CITY OF ALBUQUERQUE

February 6, 2015

**Re: Smiles for Kids Dental Office
Conceptual DMP and Conceptual Grading Plan
Engineer's Stamp Date -no stamp- (C12D054)**

project title
Smiles for Kids Dental Office
9201 Eagle Ranch Road, NW,
Albuquerque, New Mexico 87114
sheet title
Conceptual Grading Plan

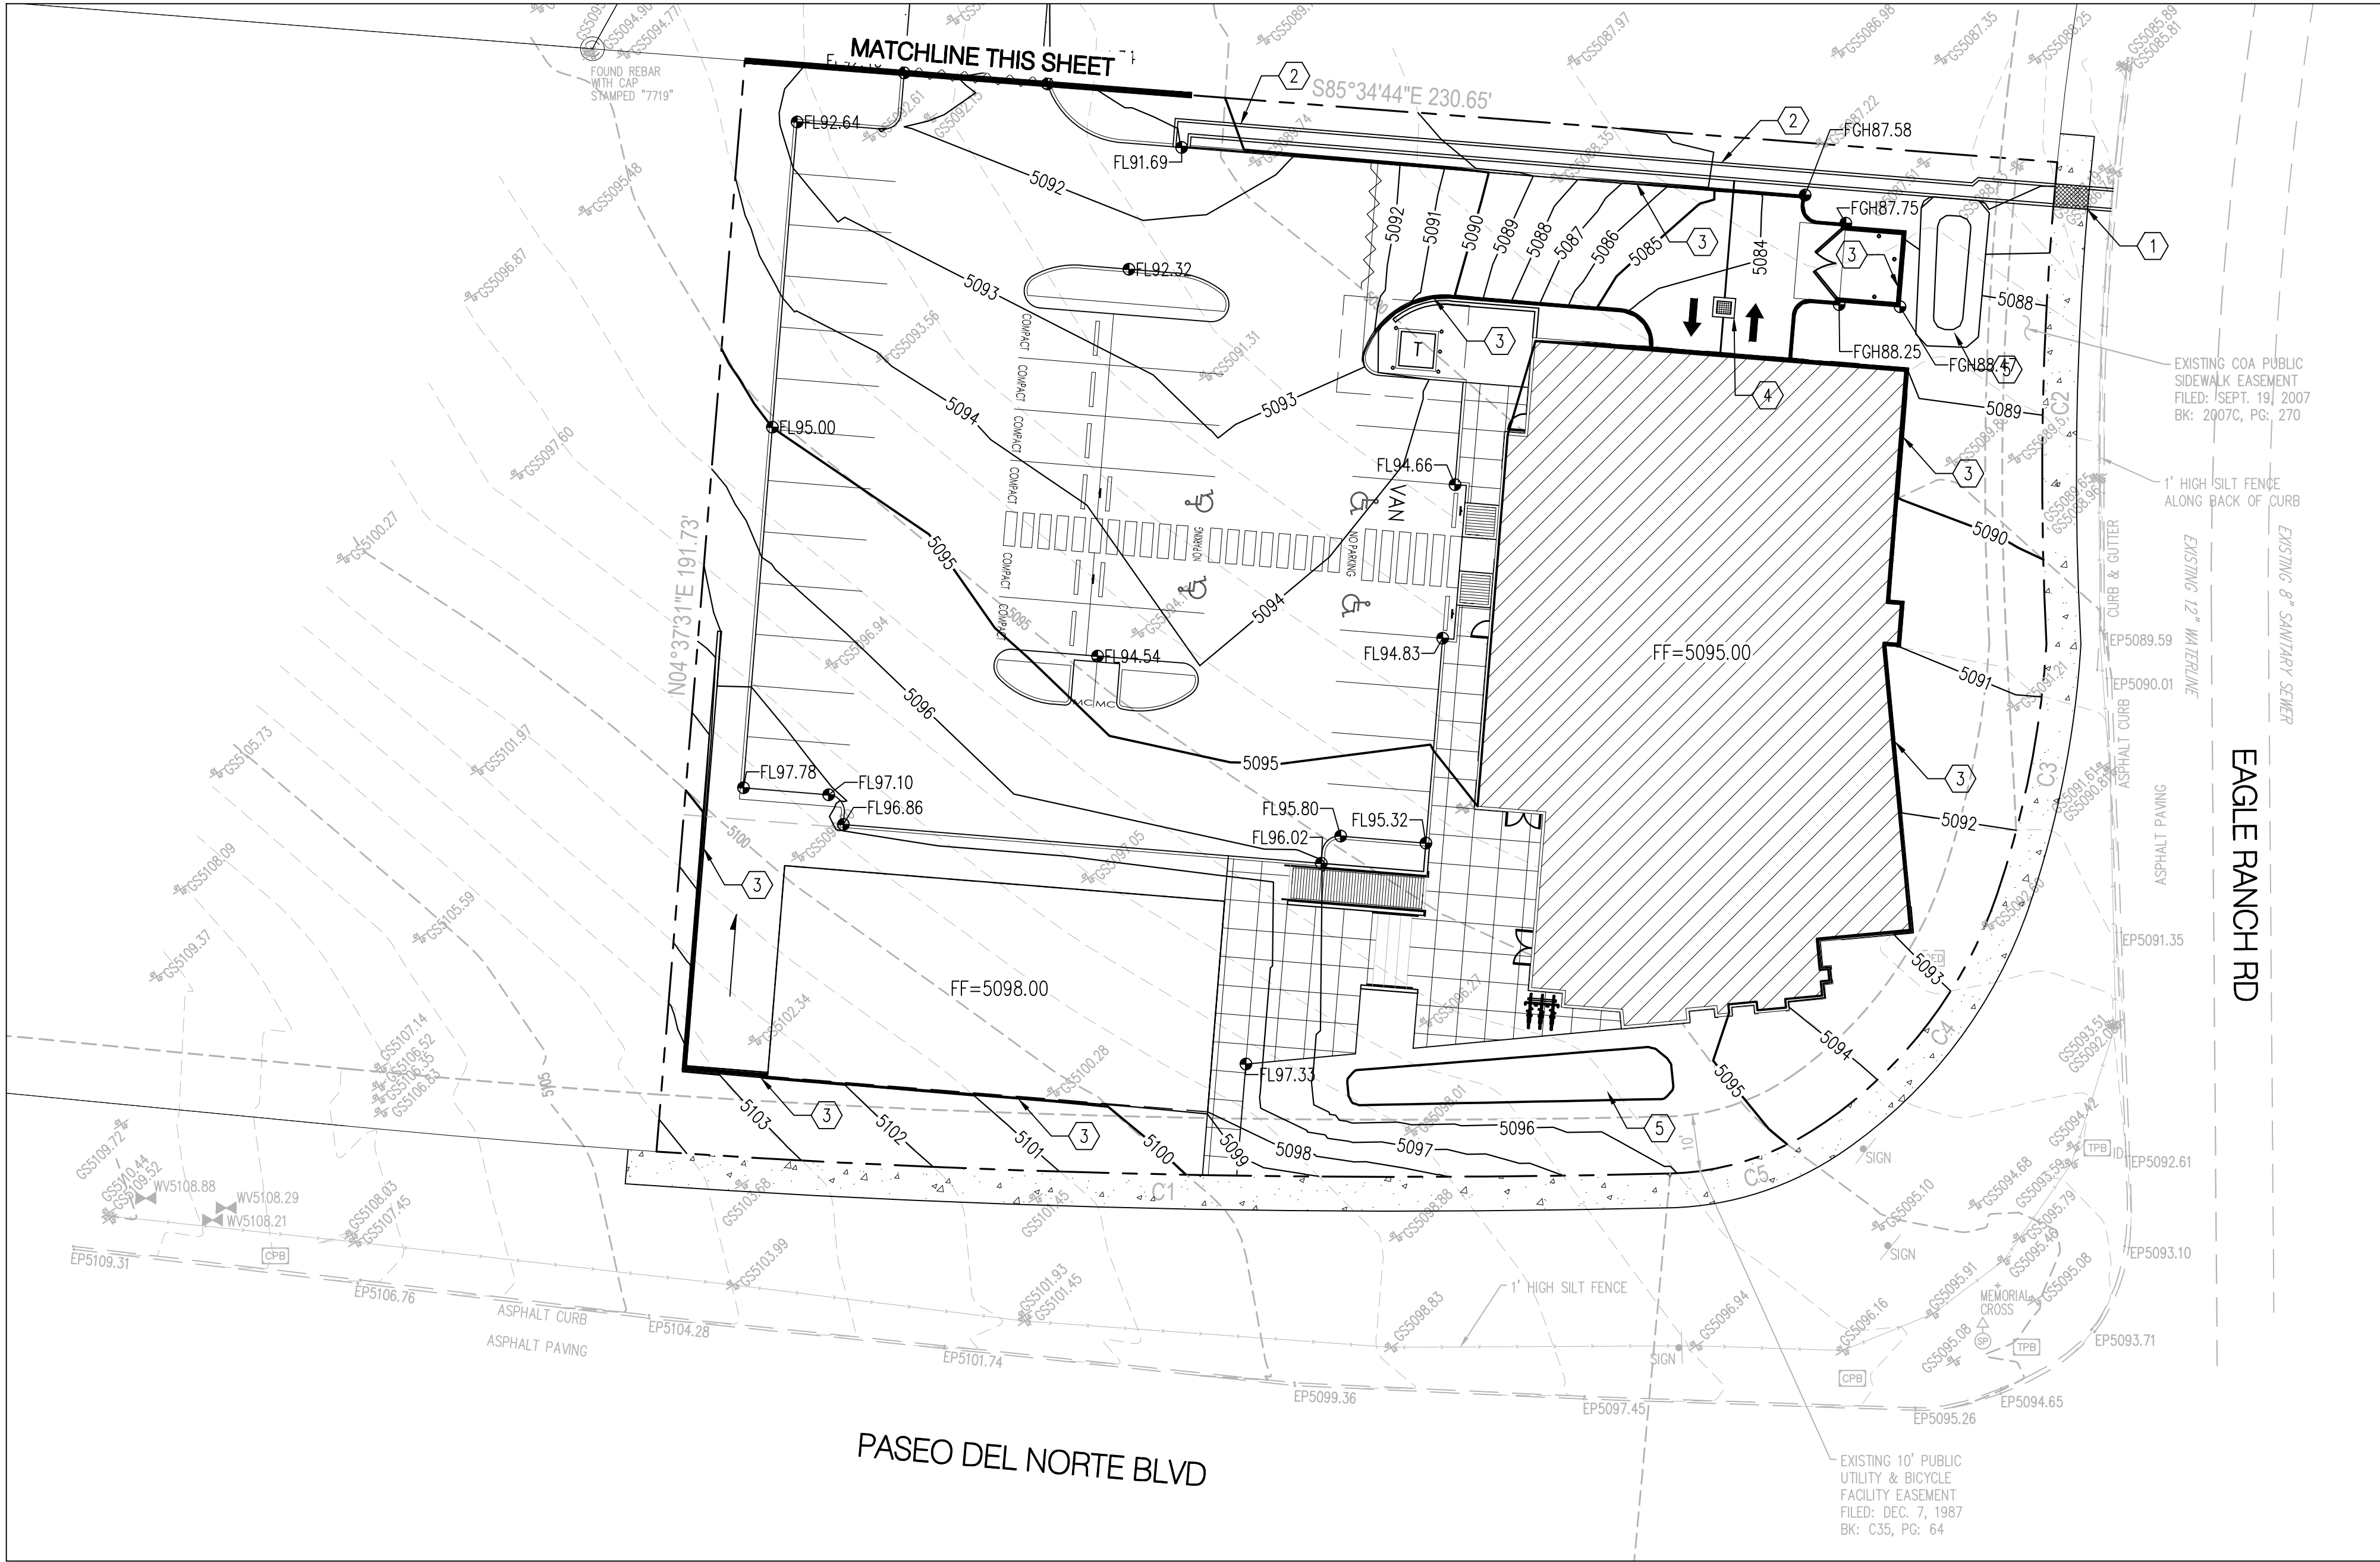
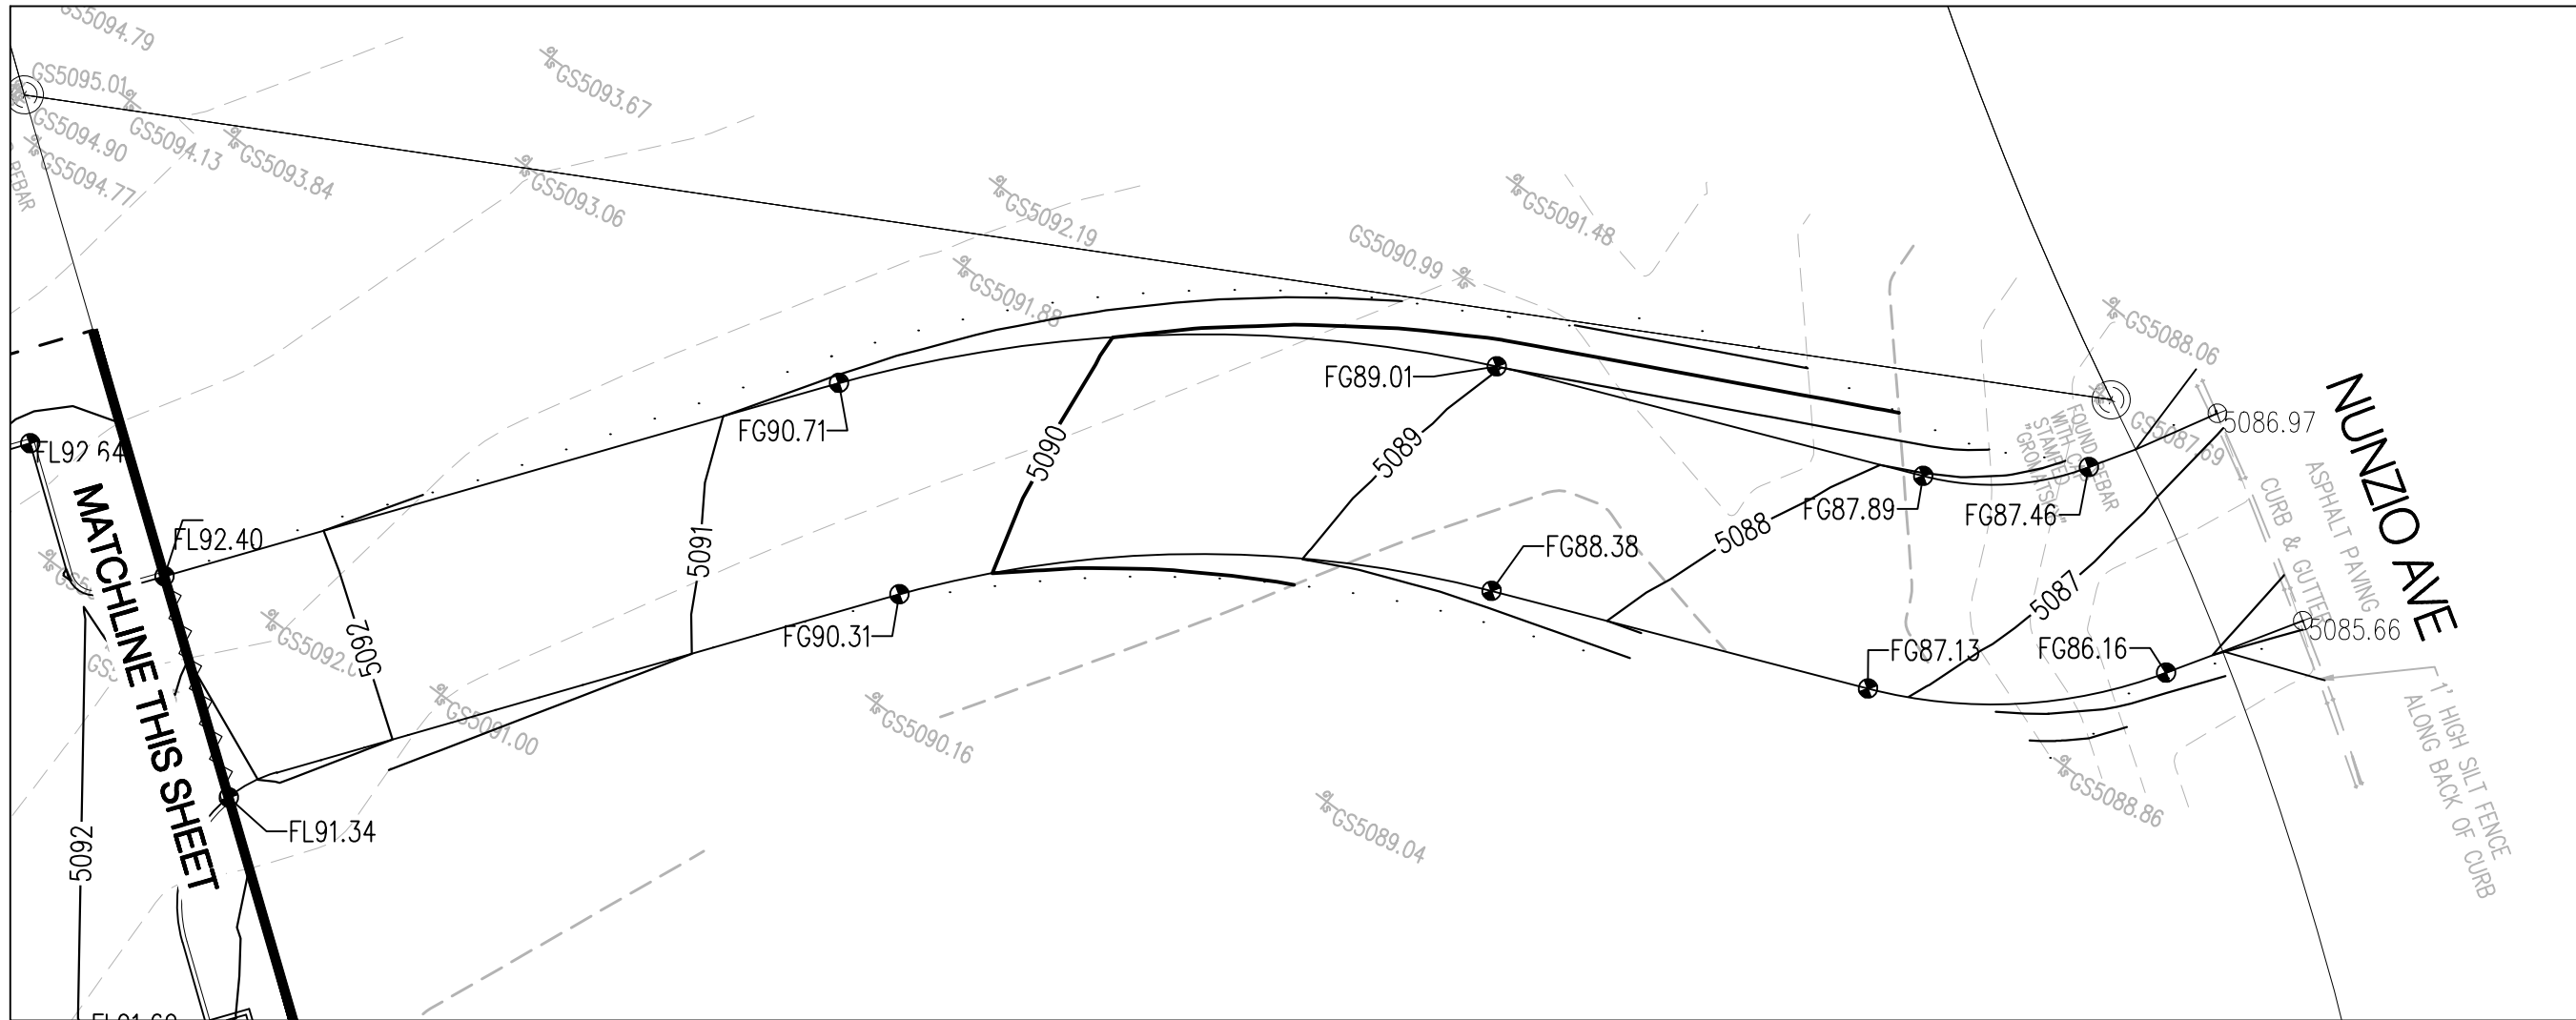
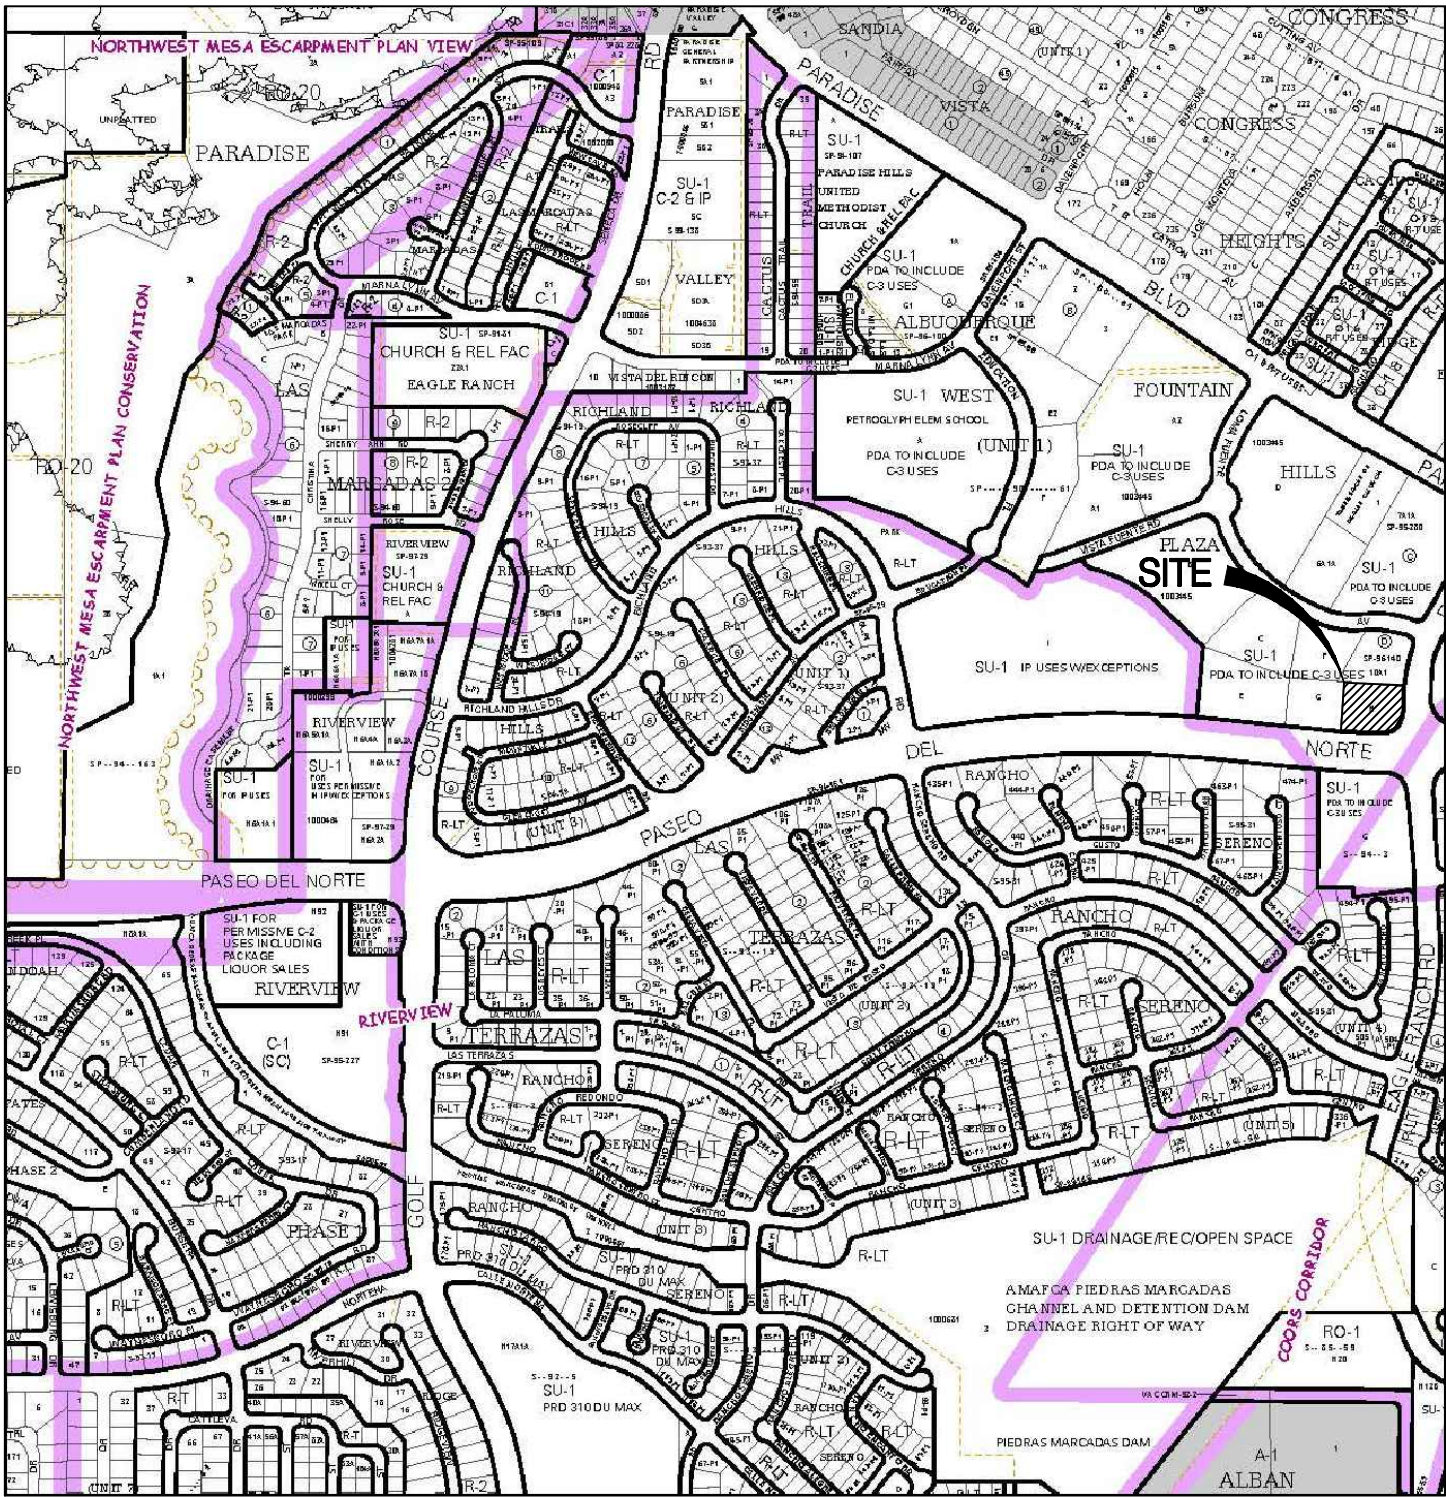
1. The plan discusses and shows first flush ponding areas, however, they don't appear to accept any flows from impervious areas. Per our discussion, first flush ponds should be relocated to the parking lot, transverse to the parking spaces in the middle of the lot (similar to Fidelity at MDS), and to the upstream portion of the ribbon channel.
